Application No: BN/43/21/HH
Site Address: 25 Skylark Way Barnham PO22 0FA
Description of works: Extension to garage and redesign roof.

Thank you for your internet representation made on 10th May 2021 which has been recorded as an objection with the comments as follows:

Existing North Elevation

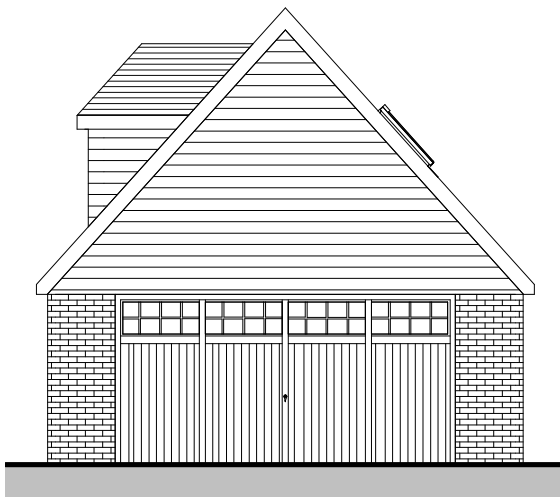
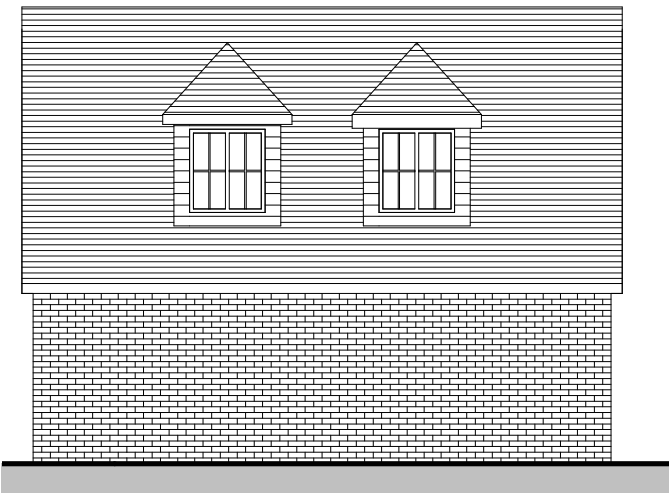
4. We further object against the installation of dormer windows on the North Elevation due to invasion of privacy. On the West Elevation of our property our windows are for the use of two of our bathrooms. This would mean the adjacent property will be able to look down into our toilet or across to our shower. This potential invasion of privacy cannot be underestimated. We enjoy where we live and the position of our house and where it sits, as it is, in relation to our neighbours. We would feel extremely uncomfortable using these rooms for their intended purpose. The dormer windows are also not in keeping with the character of our street. For example the size, appearance of other garages within the development. We also believe this will then create a 'free for all' for other dwellings to propose further extensions to their properties within the development. We would like to suggest the use of Velux windows instead for both North and South Elevations.

Proposed Ground Floor
1 : 100

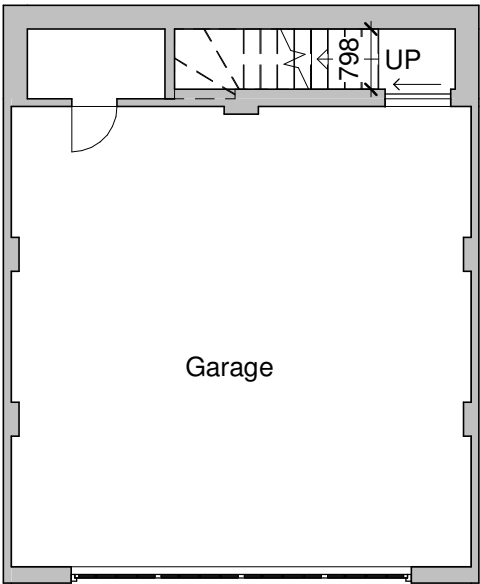
2. In the Planning Statement the designer states that the garage wall will now extend a further 1.2 metres towards the side of our house leaving a 2.4 metre gap between the proposed extension and our boundary fence. The designer further comments that this would have very little effect on our property. We cannot disagree more with this statement. With the garage being extended back towards our house it will create loss of daylight and will also feel imposing and intrusive on our enjoyment of our detached property. We had purchased this particular plot due to the positioning of the house and it's distance to other properties.
